PROPOSAL NAME: Ellensburg - Hungry Junction SP-08-00025
conditional Preliminary Approval

RE: Ellensburg-Hungry Junction Short Plat (SP-08-00025)

The Kittitas County Community Development Services Department has determined that the Ellensburg-Hungry Junction Short Plat (SP-08-00025) is a complete application and hereby grants **conditional preliminary approval** subject to the following conditions:

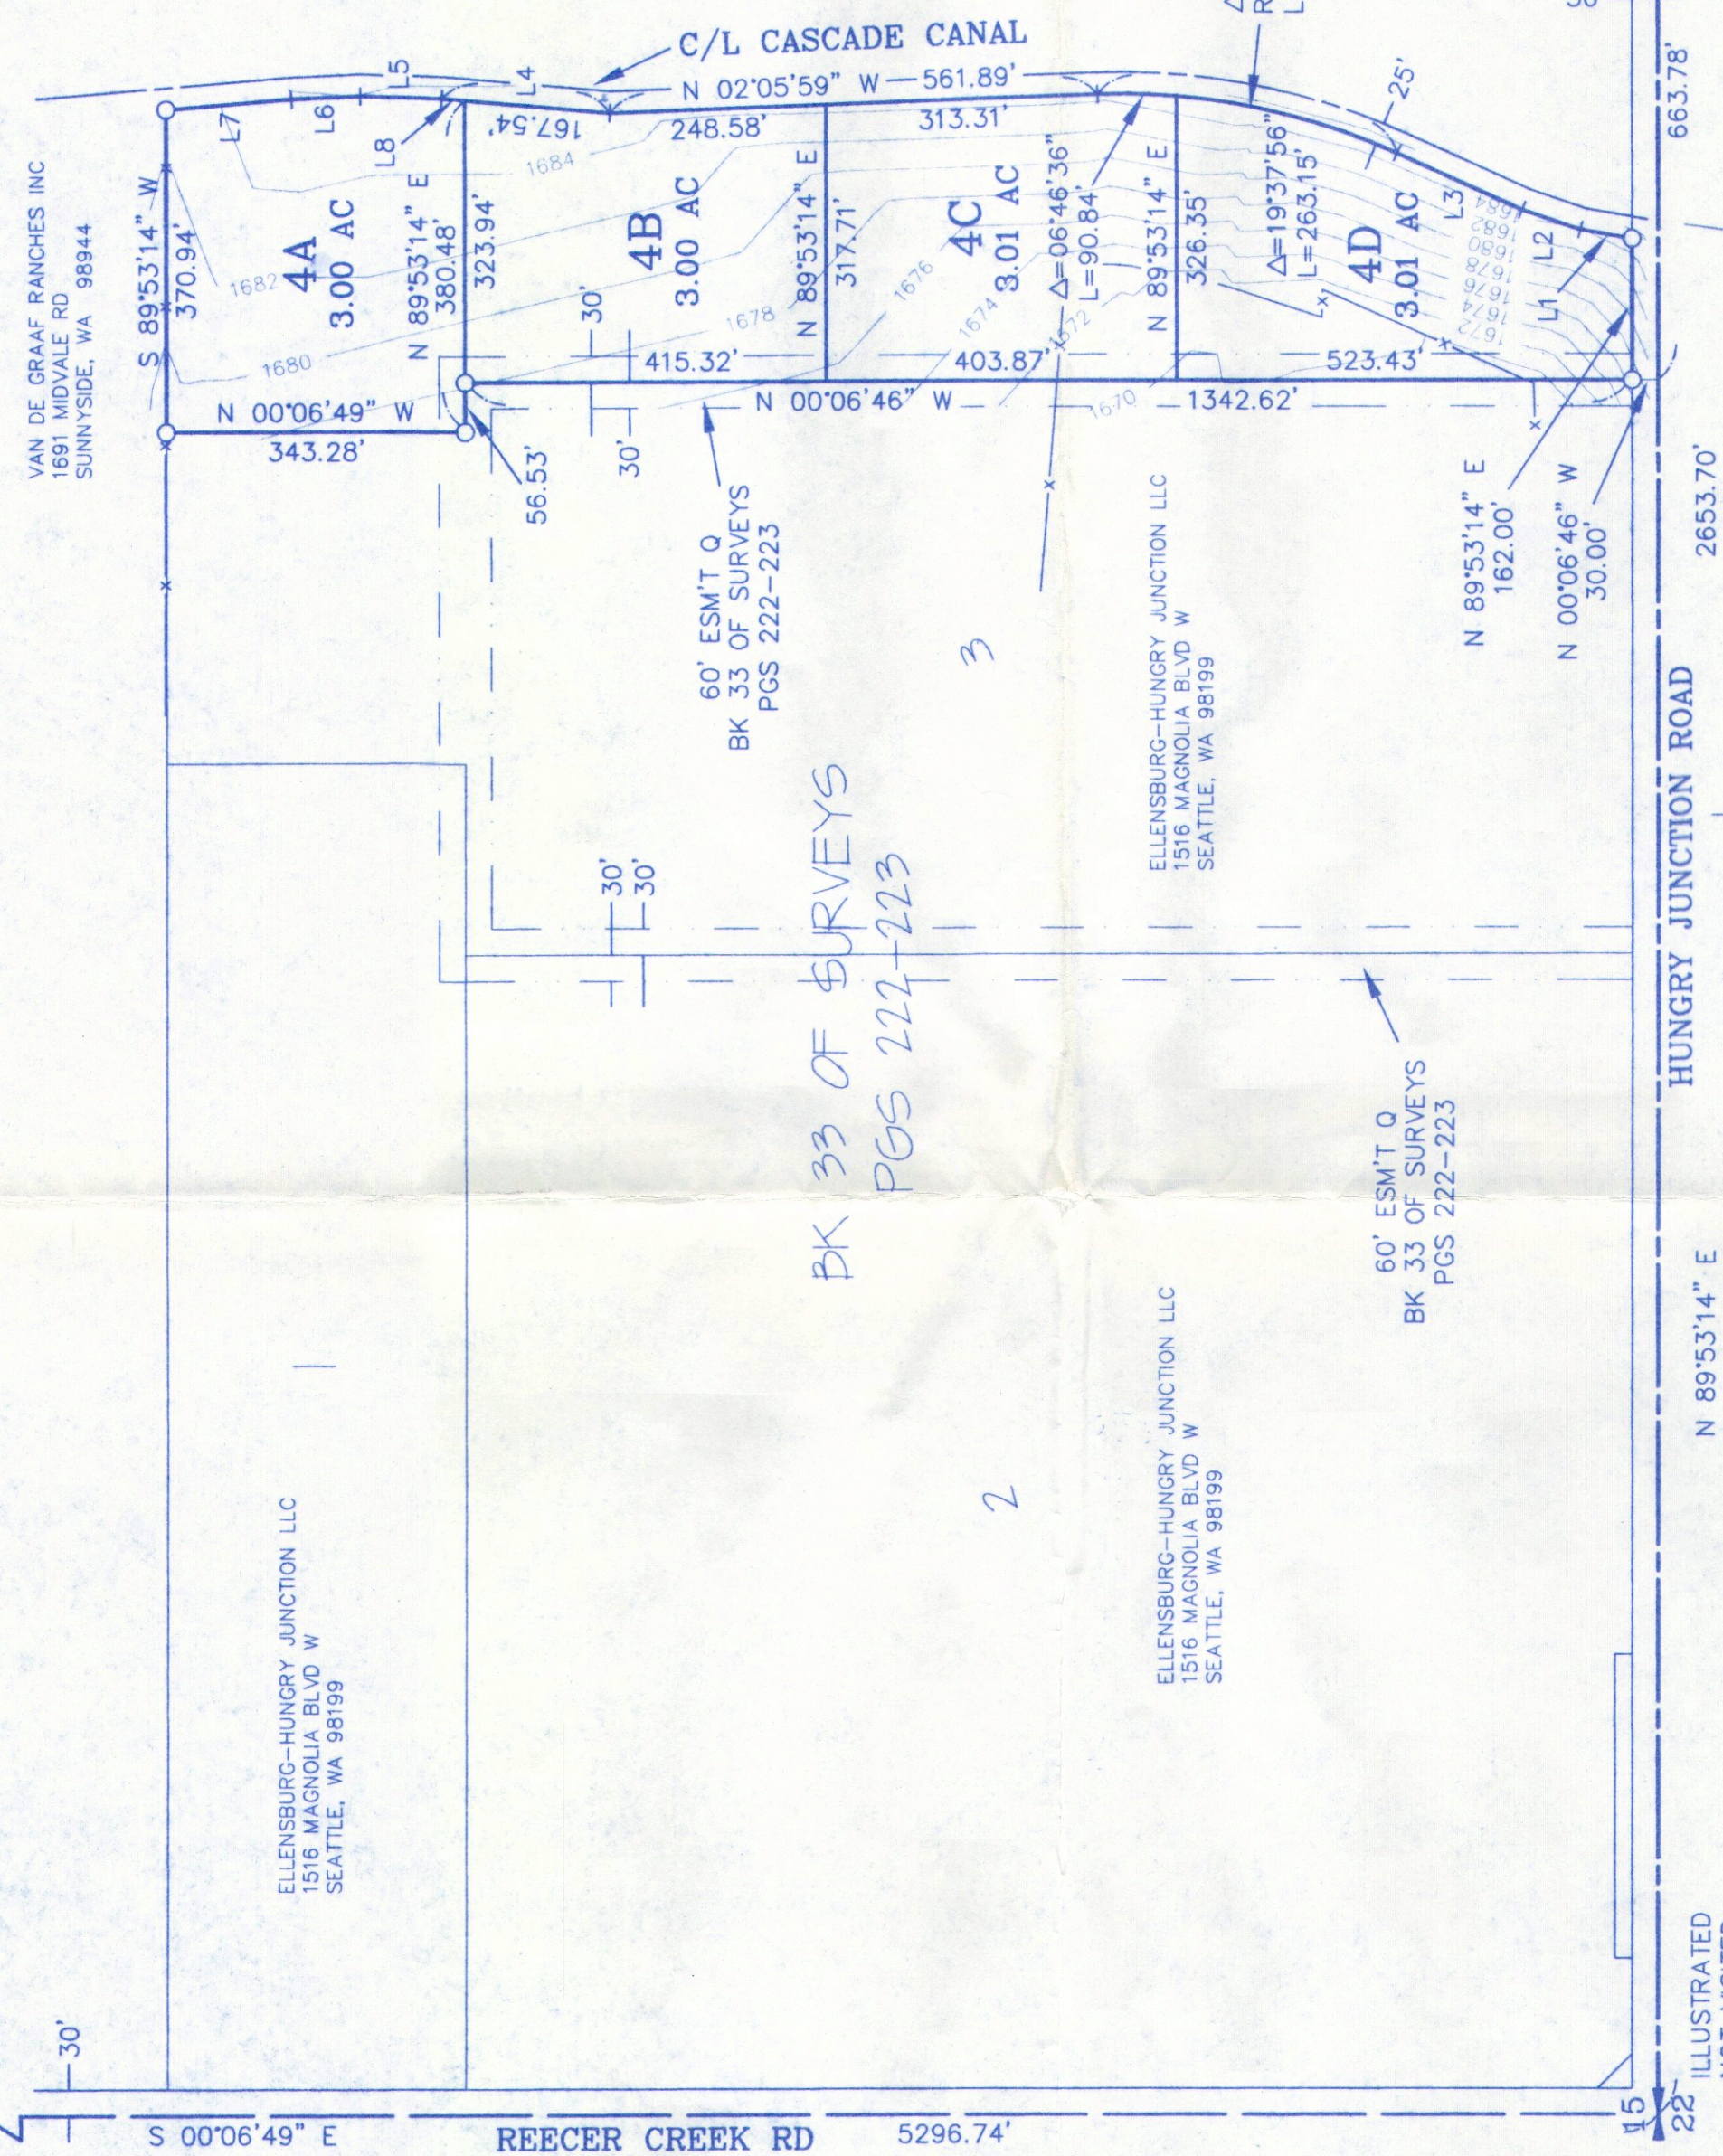
1. Both sheets of the final mylars shall reflect short plat number SP-08-00025 and an accurate legal description shall be shown on the face of the final plat.

2. Full year's taxes must be paid on all tax parcel numbers per requirement of the Kittitas County Treasurer's Office.
3. The Palustrine Emergent Saturated (PEMB) wetlands located on all lots shall be clearly delineated on the final mylars.

2. Temporary Cul-de-Sac: A temporary cul-de-sac turn-around having an outside right-of-way easement diameter of at least 110 feet shall be shown within the subject property on the final plat. When constructed, the driving surface shall be at least 96 feet in diameter. The temporary easement may be abandoned when the road is extended. Cul-de-sacs must also conform to the requirements specified by the 2006 International Fire Code. Contact the Fire Marshal regarding any additional cul-de-sac requirements.

3. Private Road Improvements: Access from Hungry Junction Road to the temporary cul-de-sac shall be constructed to meet or exceed the requirements of a High-Density Private Road that serves 3-14 tax parcels. No direct access to Hungry Junction Road will be allowed. See Kittitas County Road Standards, 9/6/05 edition.
